Subject: FW: Application CM/20/20/PL amend inaccurate Proposal description please

CM/20/20/PL

1091/DPA01

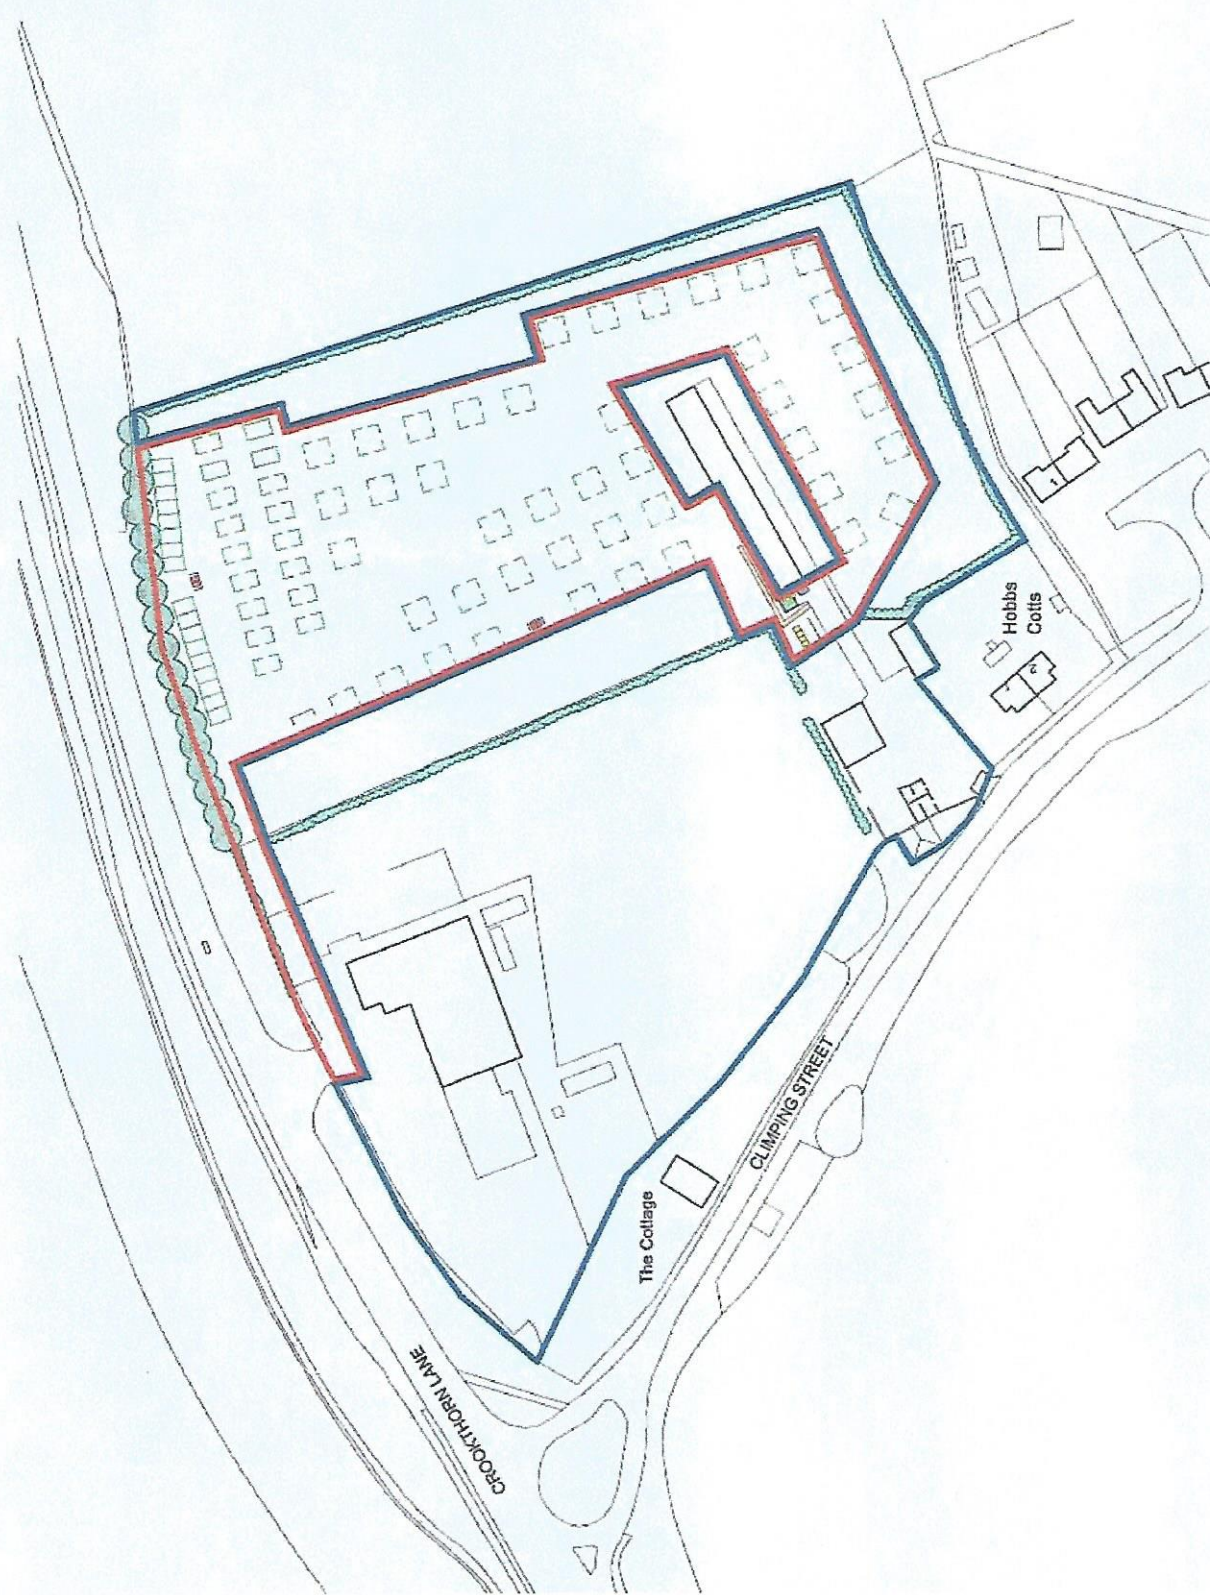
I note in your original letter you stated 'I will install fresh running water taps at each pitch to further reduce any risk of contact between Campers.'

I can't see these indicated on the substitute block plan.

To clarify can you advise if this is still your intention and if so indicate their position on the submitted block plan? Can you also advise what would happen to these taps at the end of each season when the site is not in use for camping?

The water pipe network will be temporary and we will run the blue plastic pipes on top of the ground to each pitch, a short wooden post will be driven into the ground to support the Taps. as this is the summer time, the ground will be hard enough to support this without any need for concrete. The whole infrastructure can be dismantled and removed at the end of the season and stored away for the next one. We have excellent water pressure here and

have already tested that this will work. I have a protocol in place to run each of these taps every week, so even if the pitch is not occupied the water is not stagnant in the pipes.
